Re: Wind farm development of 14 turbines with 110kV electrical substation and all related site works and ancillary development.

From: Cillian Claffey (C) <cillian.claffey@water.ie>
Sent: Tuesday 4 October 2022 16:43
To: SIDS
Subject: Irish Water Observations on Strategic Infrastructure Development SID_314602
Attachments: IrishWaterPlanningResponse_SID314602.pdf

4th October 2022

Re: Strategic Infrastructure Development – ABP-314602-22 - Wind farm development of 14 turbines with 110kV electrical substation and all related site works and ancillary development in the townlands of the townlands of Cahernacaha, Gortnabinna, Derryfineen, Gortyrhilly, Rath West, Derree, Fuhiry, Derreenaculling and other townlands, Co. Cork and Derryreag, Cummeenavrick, Glashacormick, Clydaghrone and Cummeennabuddoge, Co. Kerry.

Figure NTS-1 Project Elements

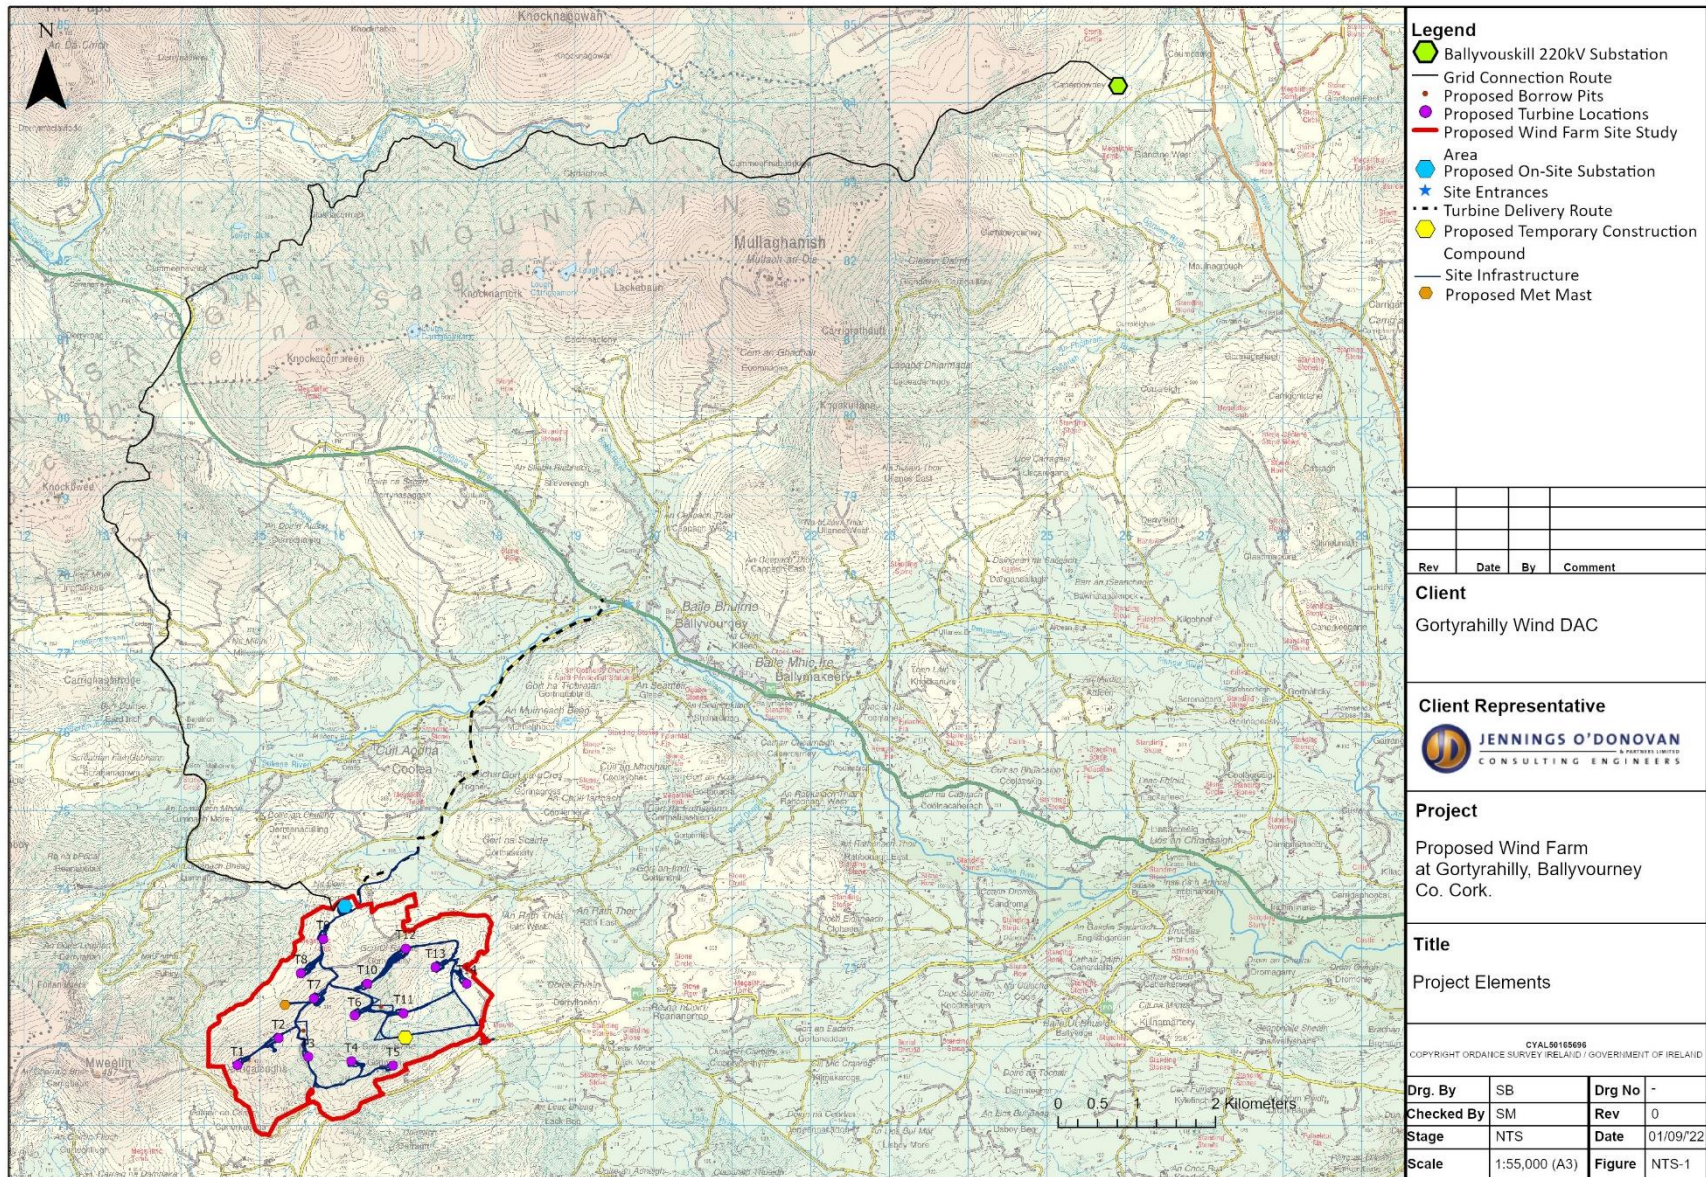
Ballingeary is a small catchment 17km² and only a small portion of the study area intersects the upper part of this catchment. From the map provided in the NTS summary (*Figure NTS-1*) it appears that approximately 3 turbines are positioned within this portion. The remaining turbines fall into the Macroom catchment which is 209 km² with the abstraction located quite far downstream.
